**39 Oak Avenue
Ickenham
UB10 8LR**

PLANNING STATEMENT

Erection of a replacement dwellinghouse

## FIRST FLOOR PLAN

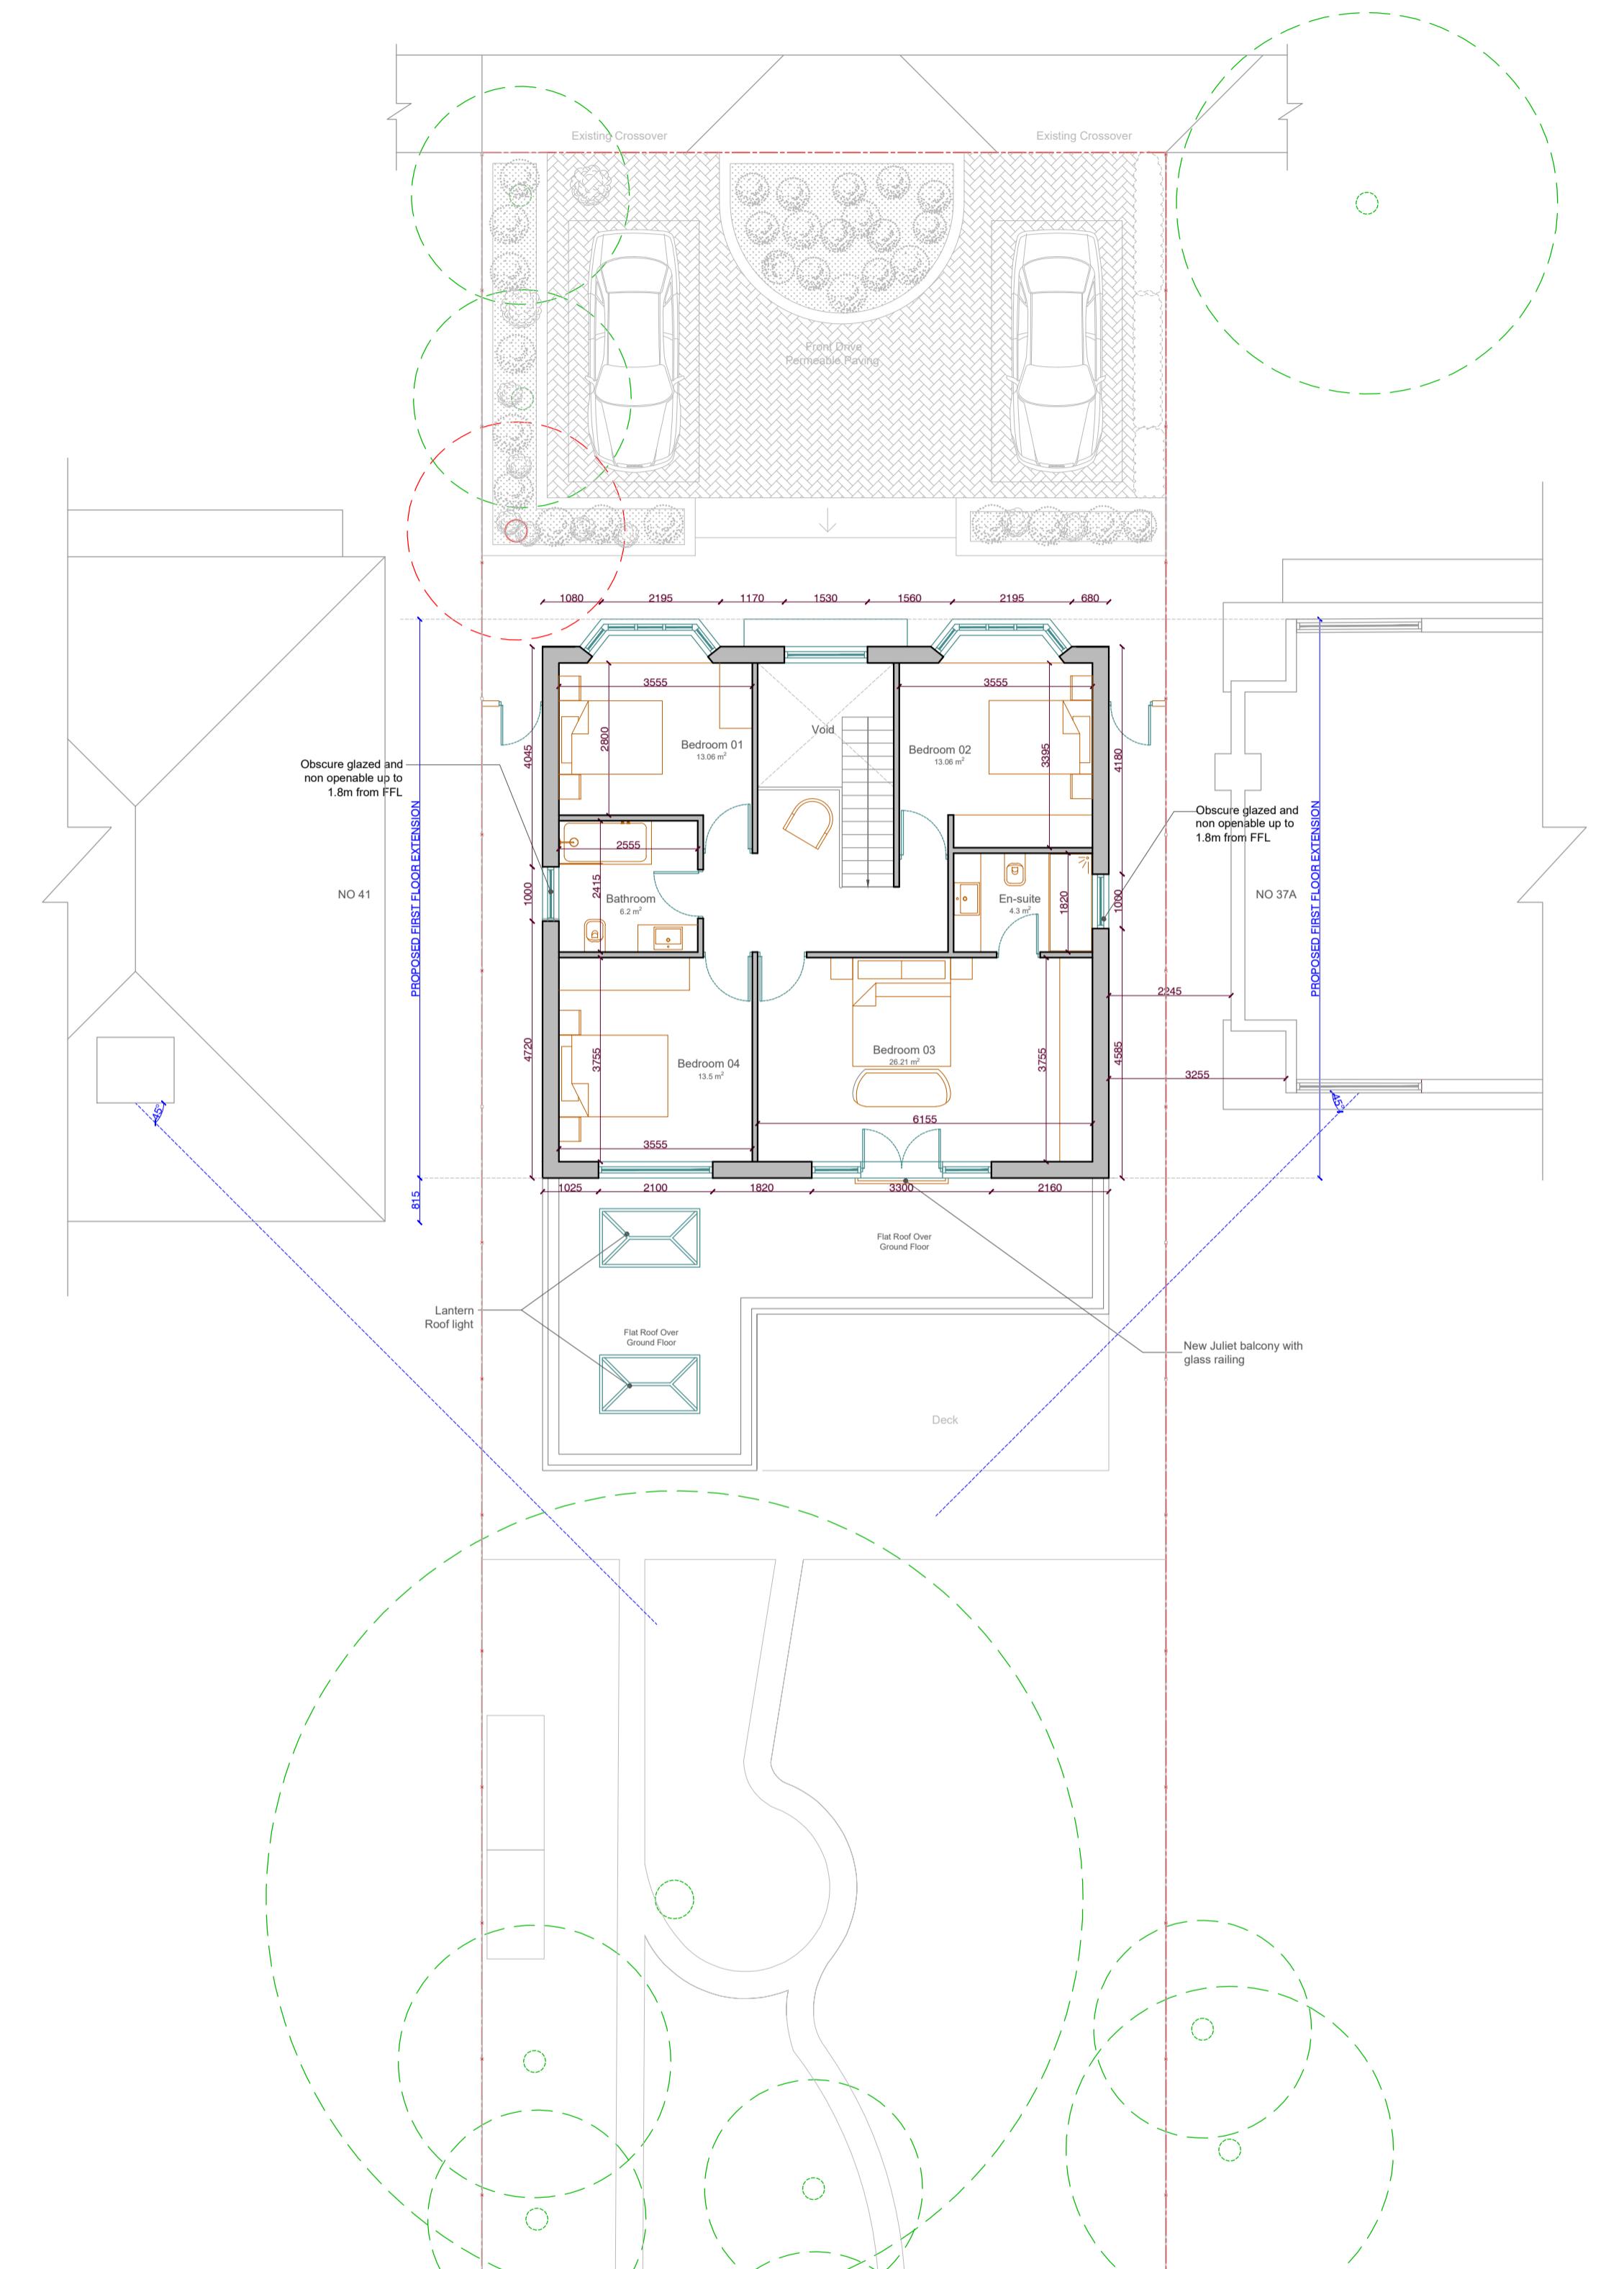
- 3.3 The council's pre-application comments were also concerned with the rear building line and how this would impact on the upper floor windows of the neighbouring properties on either side. The pre-application letter stated that:
'the rear building line would need to be reduced to overcome the harm caused to the living conditions of the occupiers of Nos. 37a and 41 Oak Avenue.' 45-degree test only relates to daylight and given position of dormers at 37a and 41, there will be unacceptable impression of enclosure which would be overbearing for these neighbouring occupiers. Also the outlook from these dormers would be severely undermined. Instead, it is strongly recommended that the depth of the proposed dwelling is reduced so that its

two-storey rear building line does not project beyond the rear dormer at no.37a (this would require a 1.6 metre depth reduction.'

3.4 However, a detailed analysis of the relationship with no.37a and no.41 Oak Avenue shows that there will be no impact to these neighbours in terms of loss of outlook or with regard to creating a sense of enclosure and this is presented below.

3.8 The proposed first floor plan shows that the edge of the proposed first floor flank wall will be 3.2 metres away from the edge of the dormer at no.37a and that there is a very good separation distance between the first floor of the proposed dwelling and no.37a's rear dormer.

3.9 Most significantly, the image above shows a 45-degree line drawn from the rear dormer window of no.37a and it is clear that even if this line were moved to edge of this window (closest to the application site) that the proposed first floor would not break this line and that there is clearly no loss of outlook to this window and nor will it suffer from a sense of enclosure. The proposed rear building line will not be readily visible from the rear dormer window of no.37a and will therefore have little to no impact on this neighbour. It has therefore been demonstrated that the proposed first floor building line will not adversely affect the amenities of the first floor rear windows of no.37a Oak Avenue.

ROOF PLAN

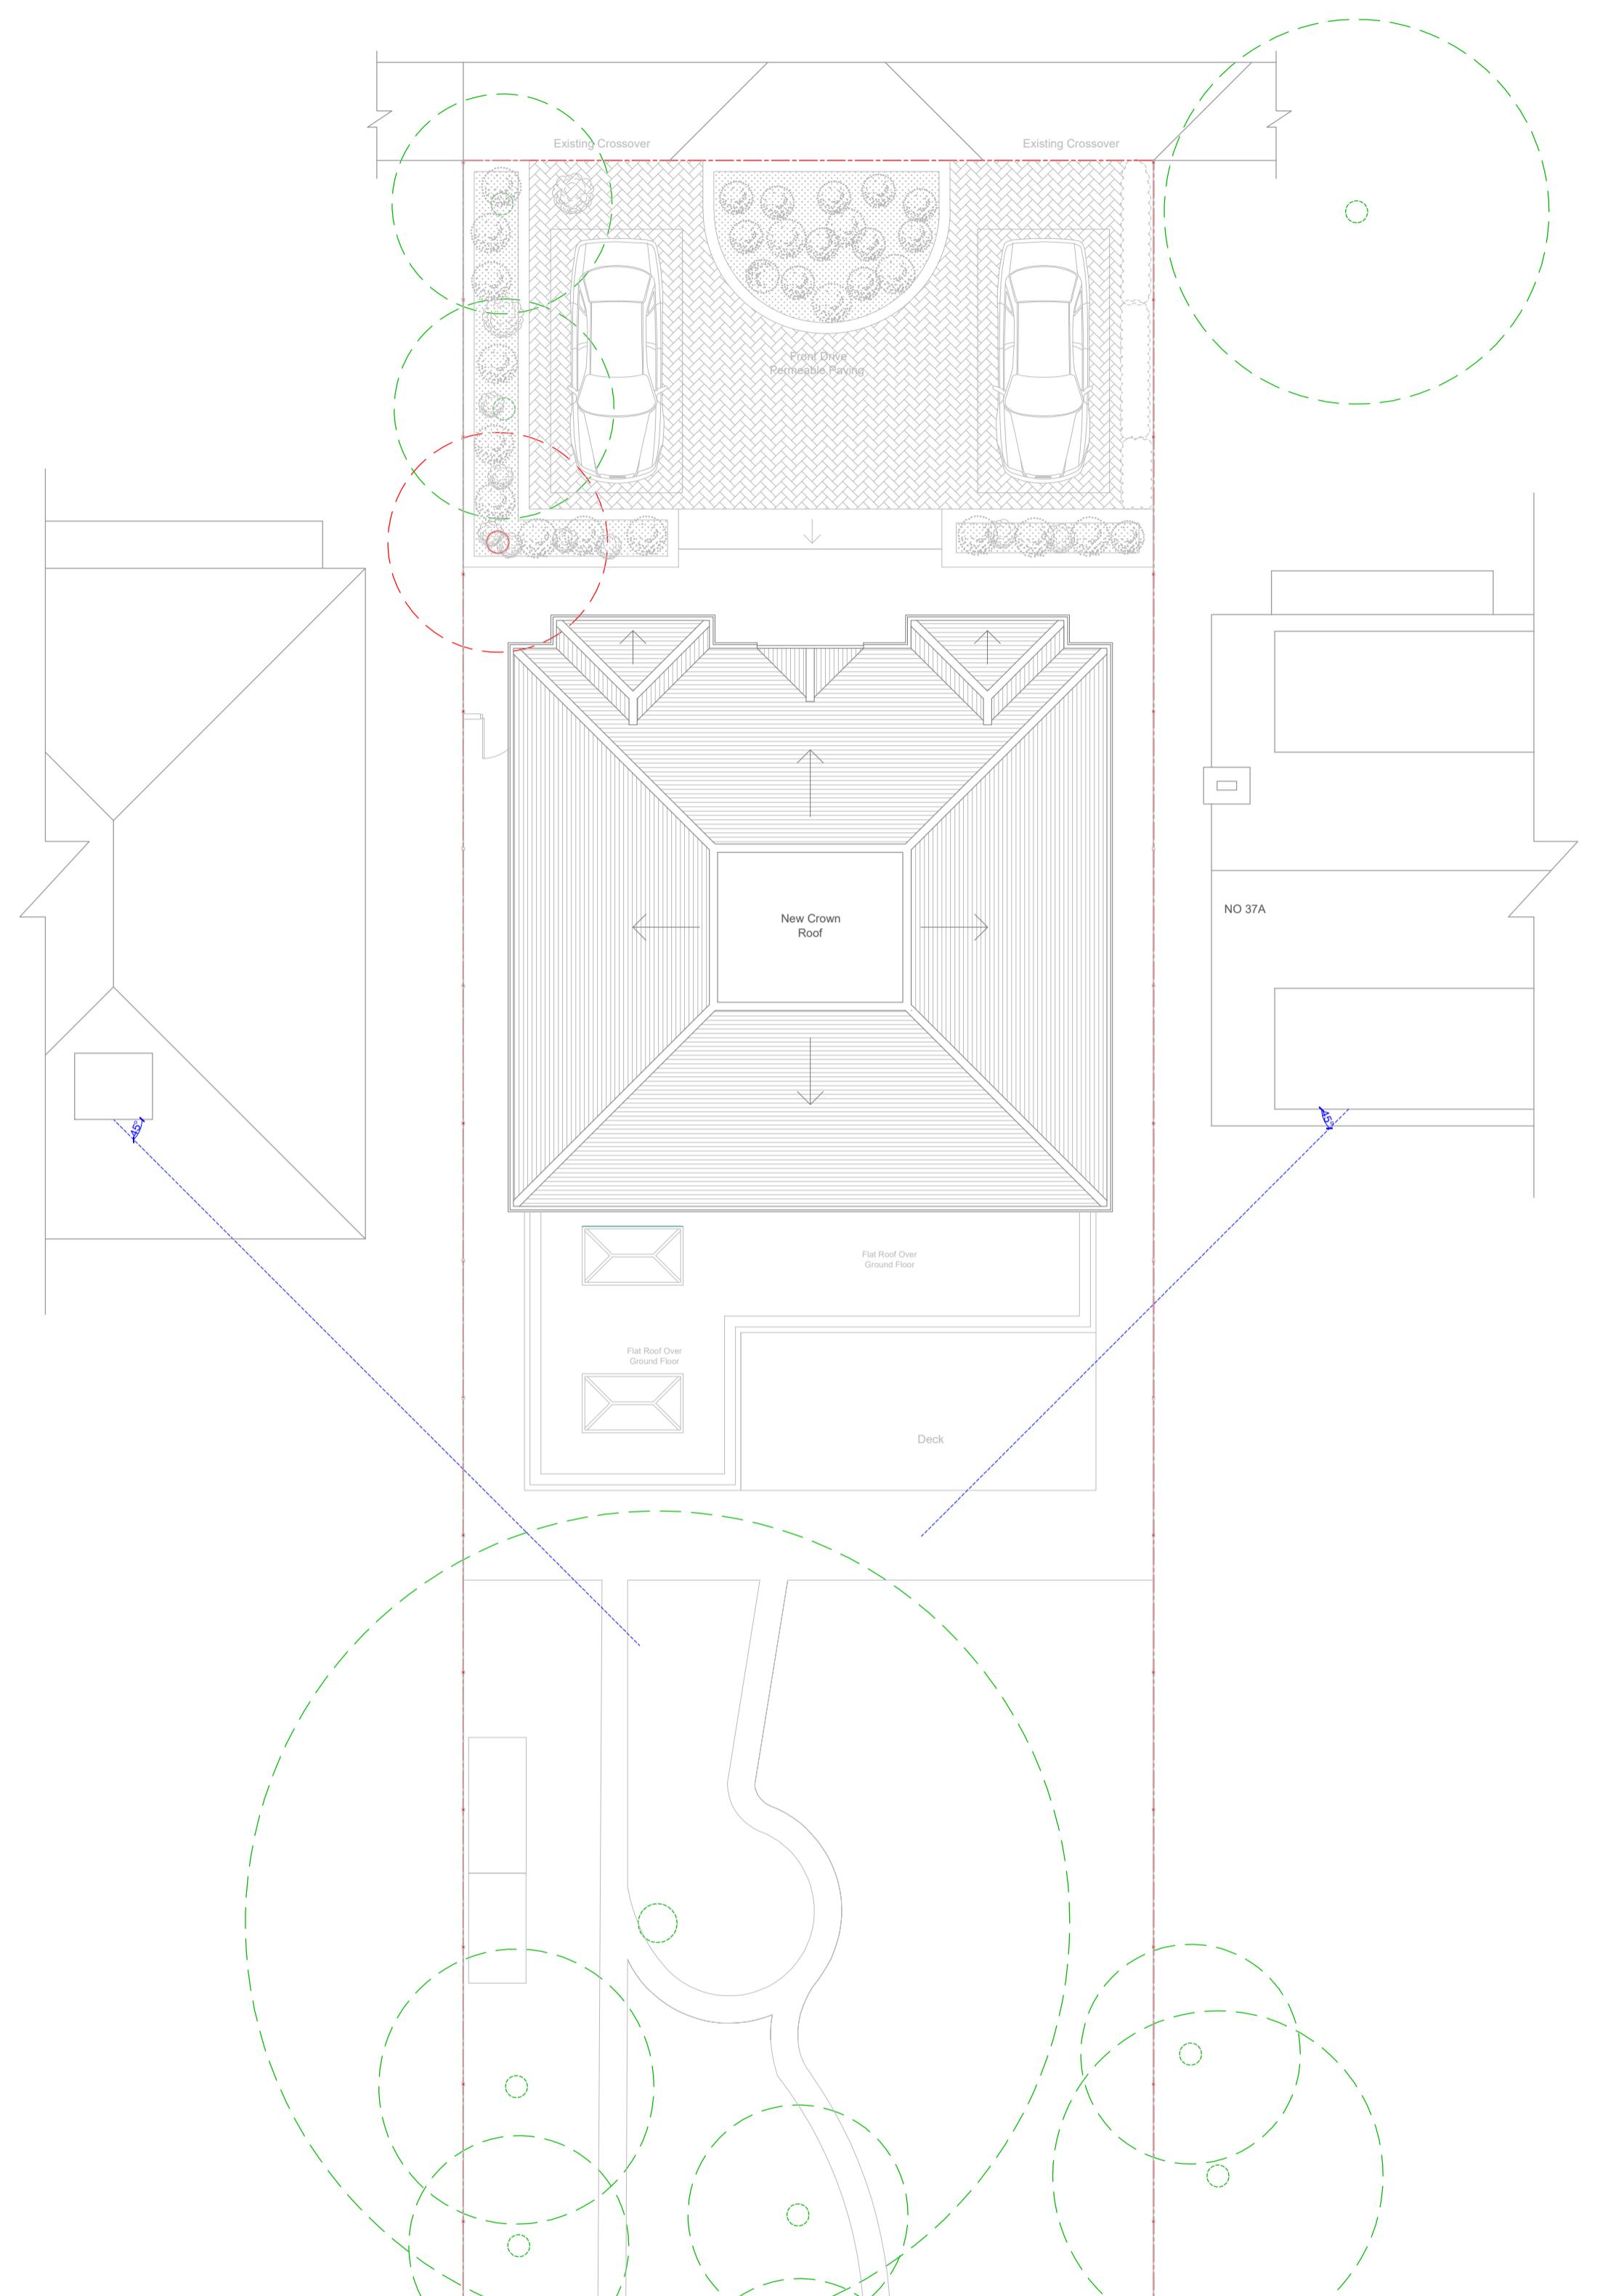
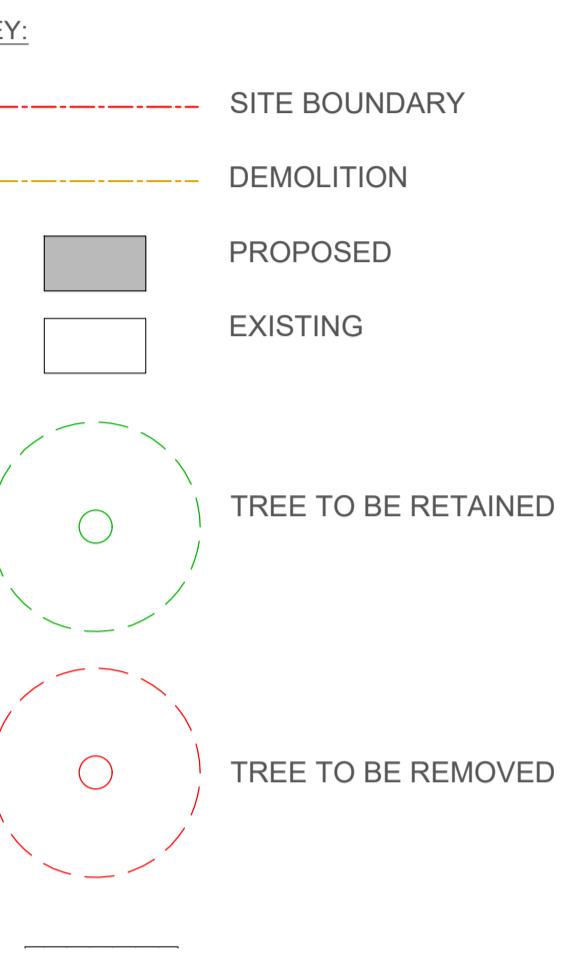
- 2.1 This council's pre-application response was supportive of the design concept of the replacement dwelling but requested that amendments be made to the crown roof profile in that '*the central flat roof element is reduced to resemble the appearance of the crown roof profile at no.38 Oak Avenue.*'
- 2.2 The crown roof profile has been amended in accordance with the council's request and this is demonstrated in Fig.1 below.

SIDE ELEVATIONS (1/2)

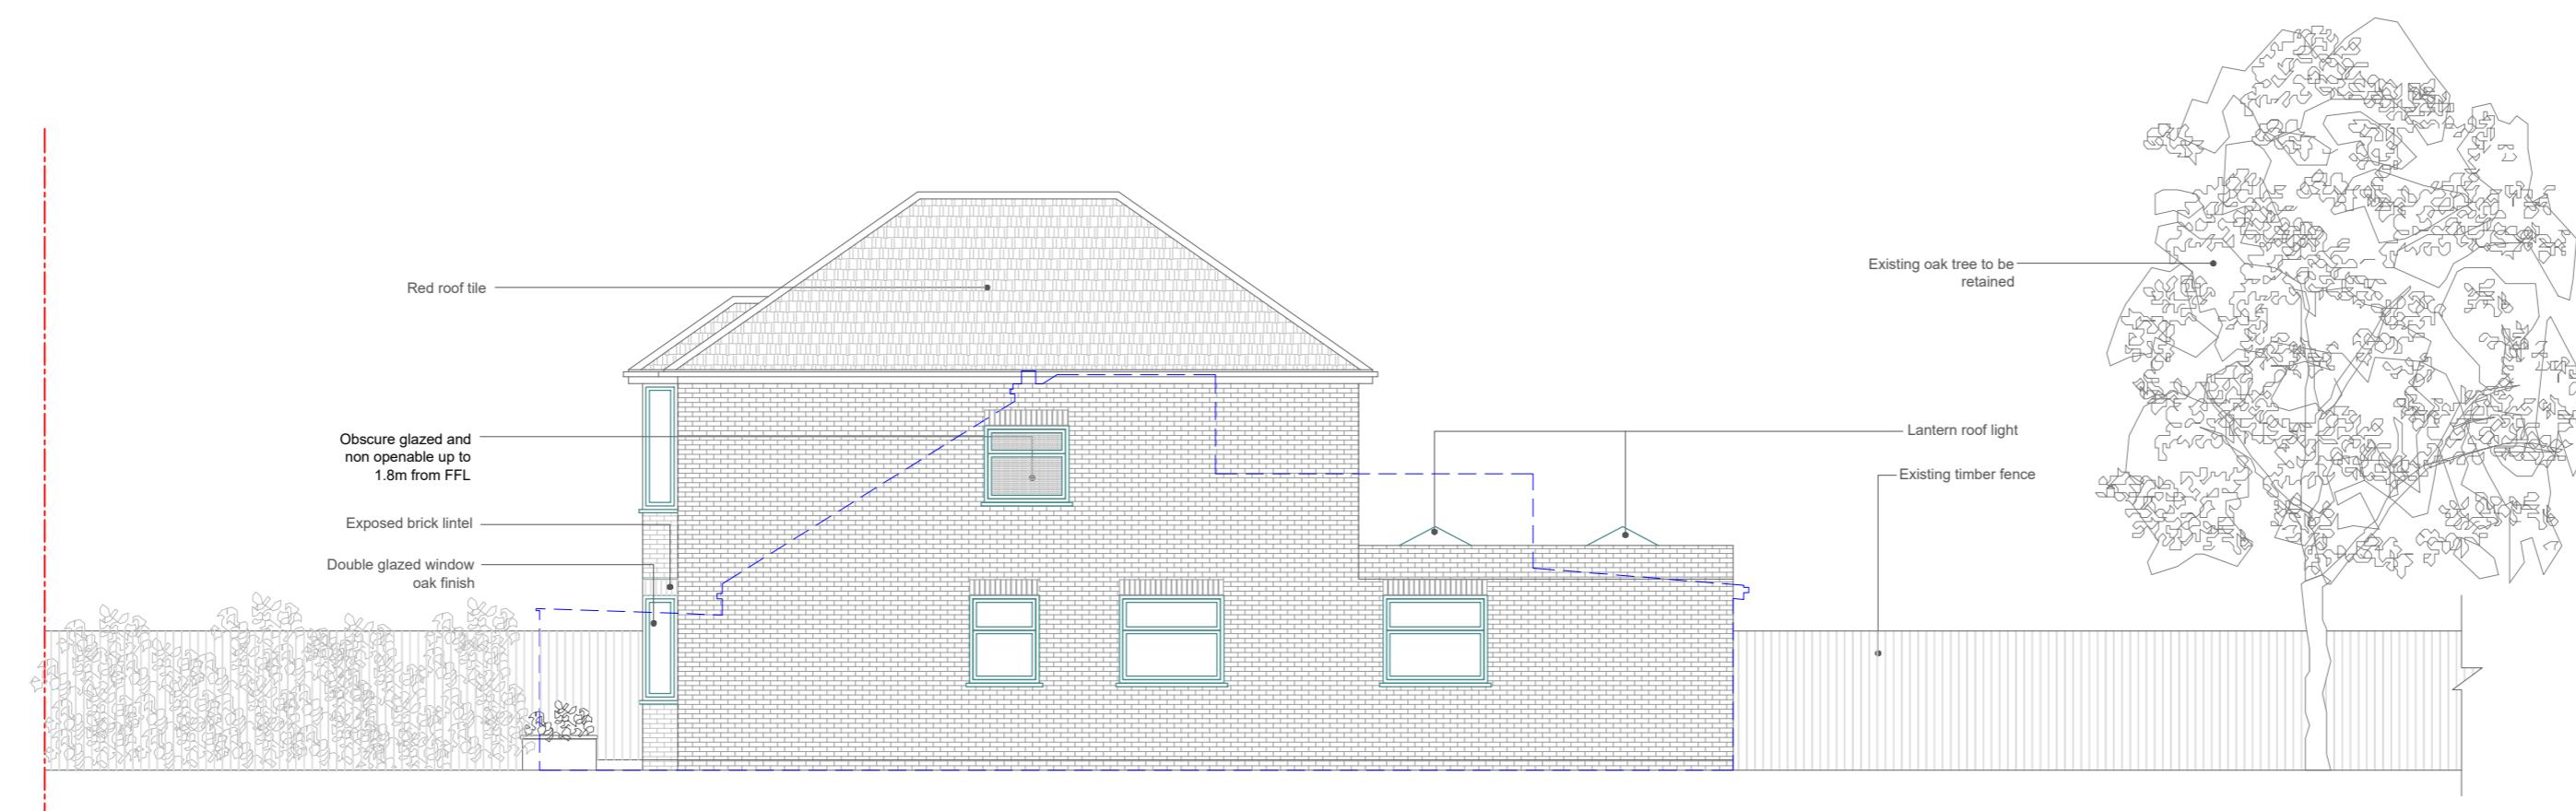
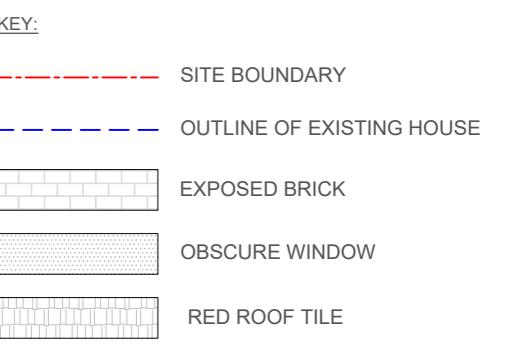
3.21 The final request from the planners in relation to residential amenity was that the side elevations demonstrate that the ground floor and first floor bathroom windows be obscure glazed and non-opening up to 1.8 metres above finished floor level and this annotation has now been added to the proposed drawings.
